08 August 2018

PLANNING APPLICATION: 2018/62/91661/E

Outline permission for residential development and facilitating engineering operations and full planning permission for access and spine road; Land At, Walkey Terrace And Brunswick Street, Heckmondwike, Kirklees

The Coal Authority Response: Material Consideration

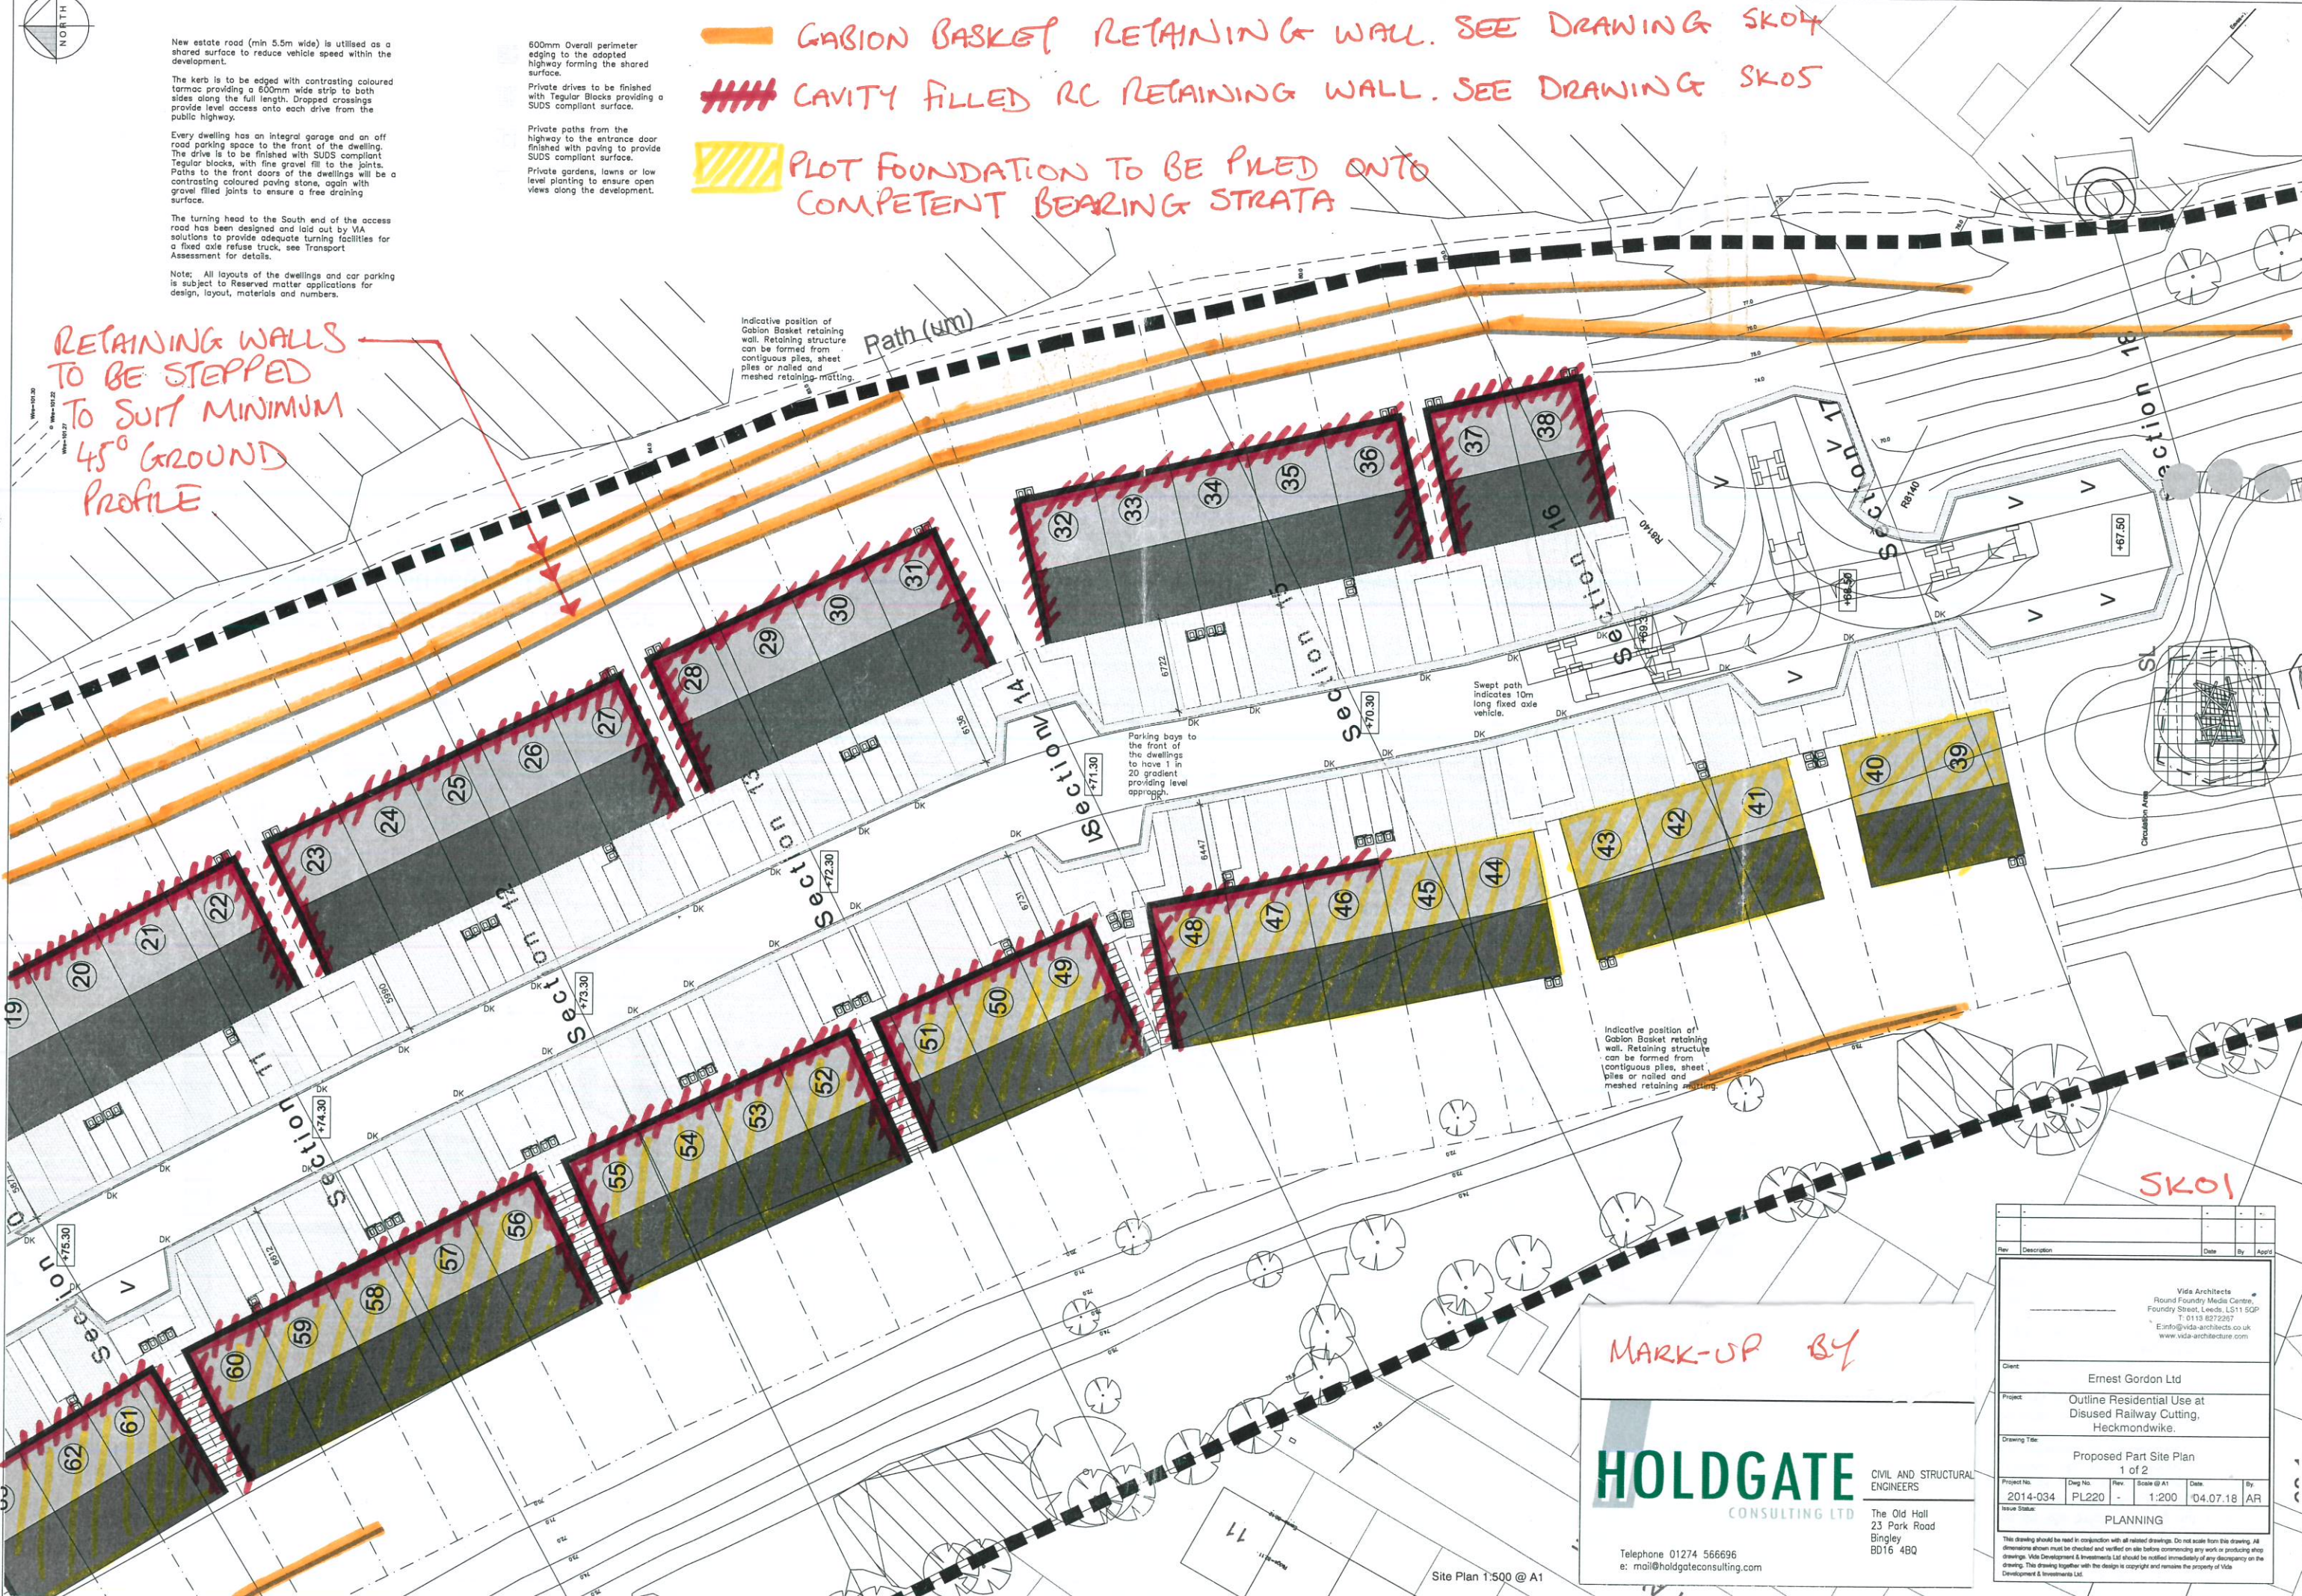
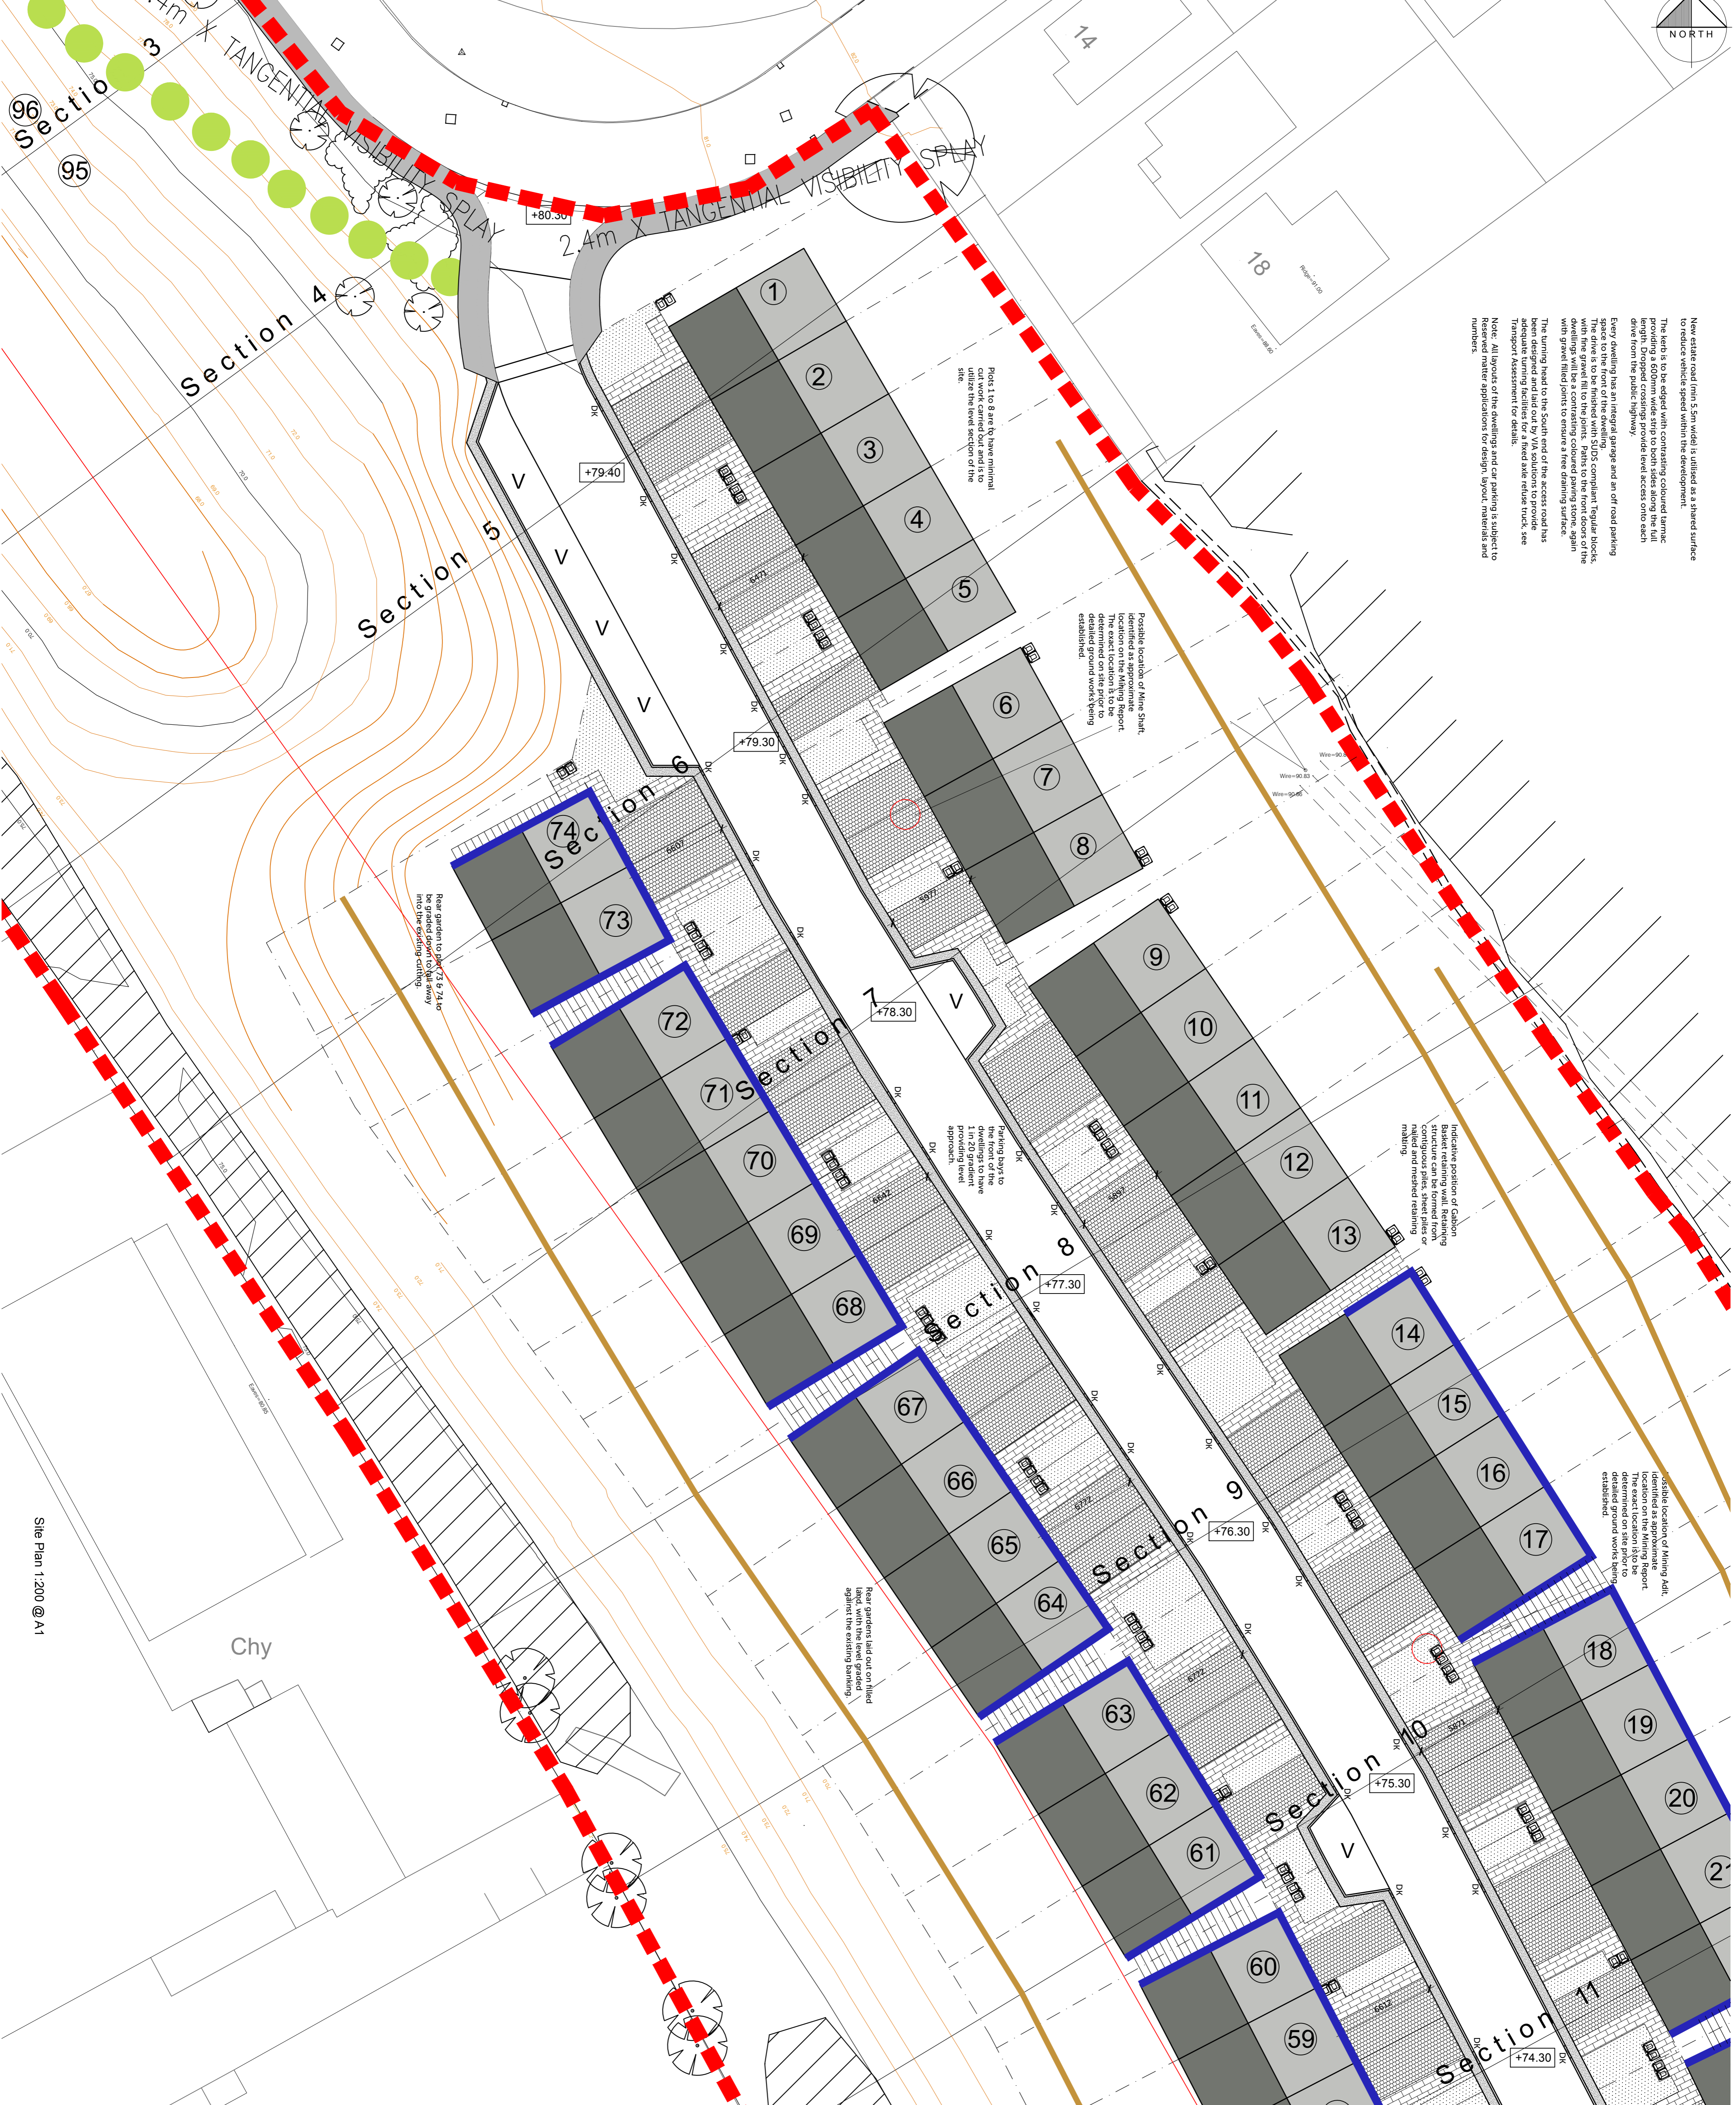
The Coal Authority records indicates that both recorded and unrecorded coal mining has taken place at shallow depth and the presence of four recorded mine entries; two within the application site boundary; and two just outside the western side of the site. The Coal Authority hold no treatment details for these mine entries, and there could be some deviation, by several metres from the current plotted positions.

As the Coal Authority holds no records of any treatment details for the mine entries this could result in the two off-site mine entries being present within the application site boundary. Whilst we can see that this area is also a steeped bank area (google map images only) we would request that further commentary on these two mining features and / or confirmation from ARP Geotechnical Limited that there will be no disturbance to the bank to facilitate the proposed development. We consider it would be prudent for the report author to provide a statement to the LPA in order that you are satisfied that site and surrounding properties will not be affected from any forms of development taking place within the western part of the site.

- * As part of the reserved matters application the submission of a report of findings arising from the intrusive site investigations and any remedial measures necessary, including the submission of a layout plan which identifies the exact location of the mine entries and appropriate zones of influence of the mine entries on site, and the definition of suitable 'no-build' zones;
